ITEM 5.1 (c)

Issue/ Objection:
Solar Impact/
Overshadowing

85 Harrington Street
The Rocks
GOLDEN AGE & HANNAS THE ROCKS

RESPONSE TO DoPE
ITEM 5.1 (c)

TITLE
Elevations
West Elevation (Gloucester Street)

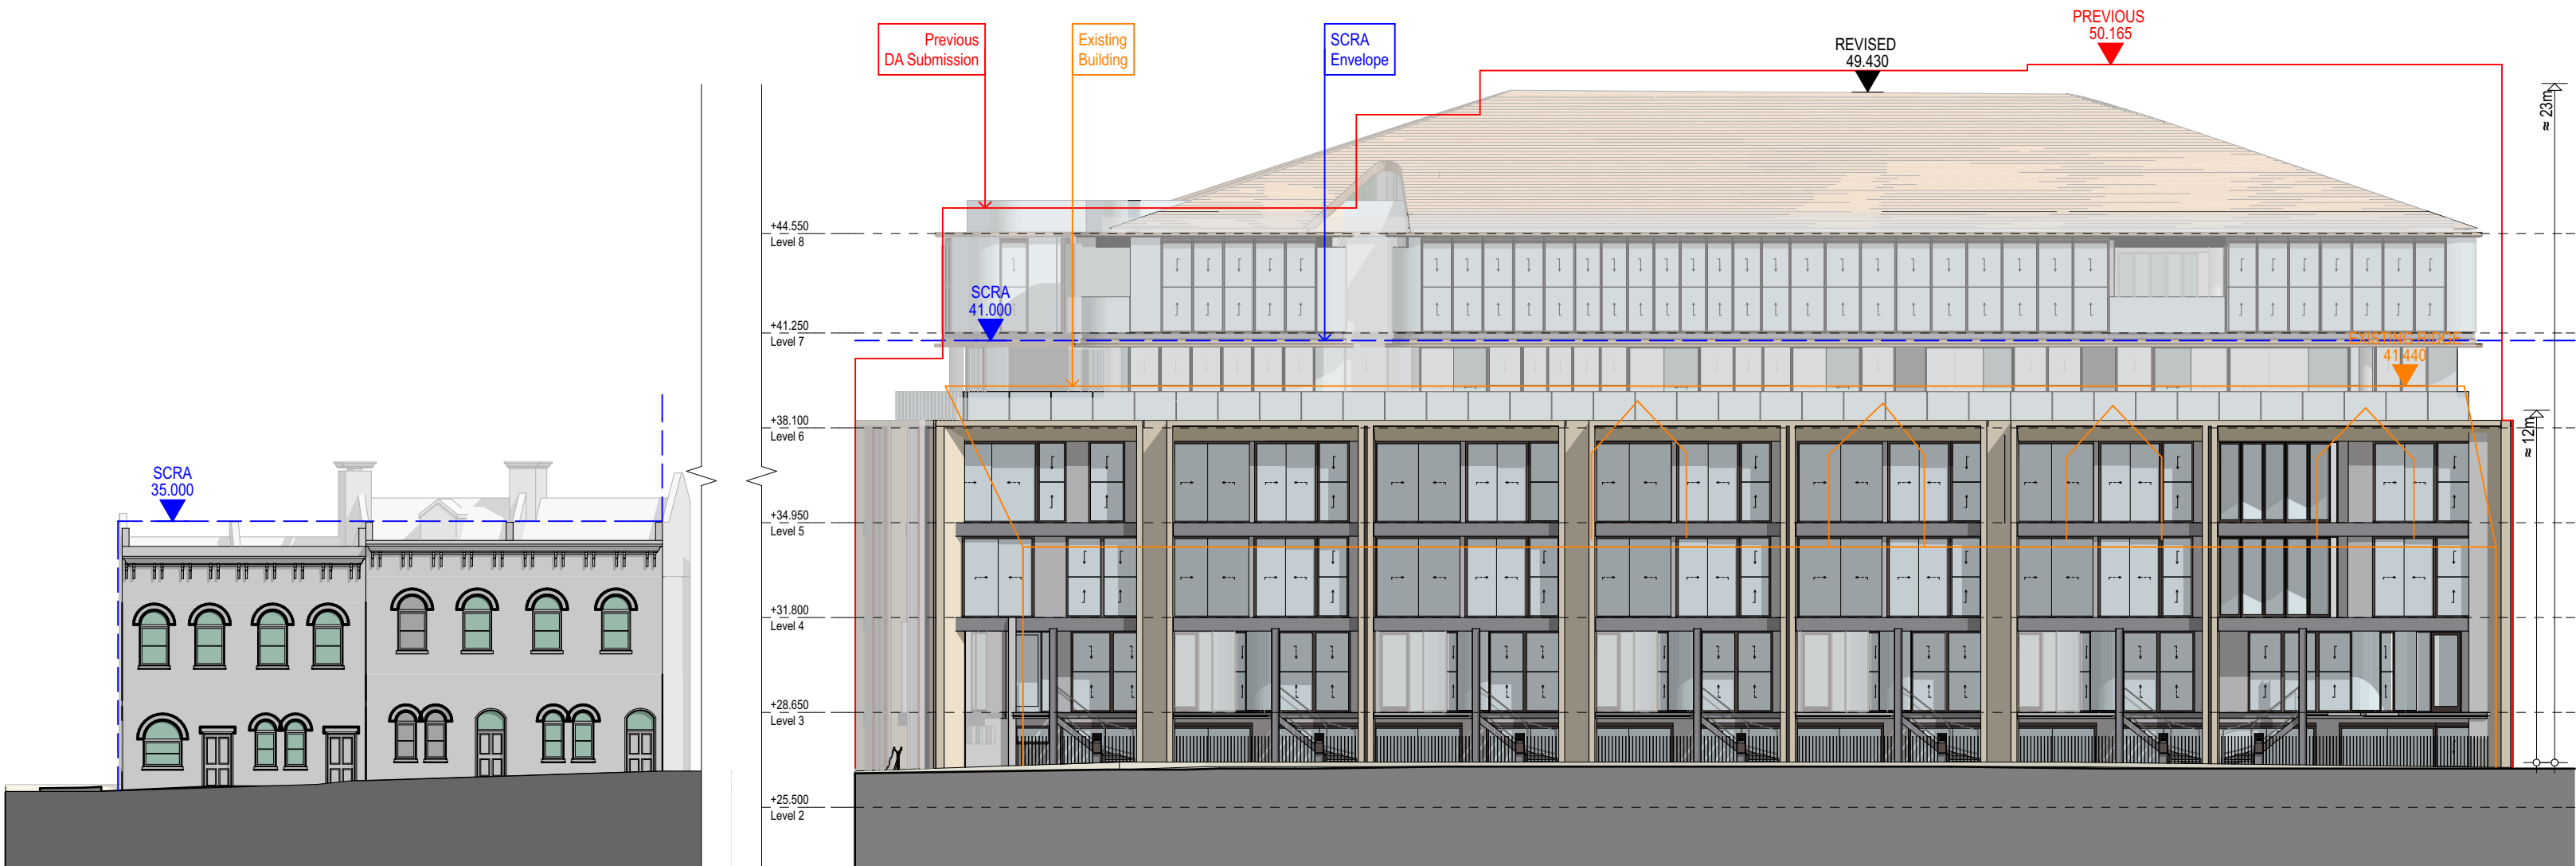
Description:
Revised and enlarged 9am mid-winter elevational shadow diagrams clearly illustrating the extent of overshadowing compared to a SCRA compliant scheme. 9:30am diagrams should be provided if any shadow increase to neighbouring properties in Gloucester Street will occur at 9am

Response
Revised diagrams have been provided showing overshadowing impacts for Gloucester Street. These have been provided at both 9am and 9:30am for both March, June, September 21. The analysis concludes that the development largely improves on a SCRA compliant scheme.
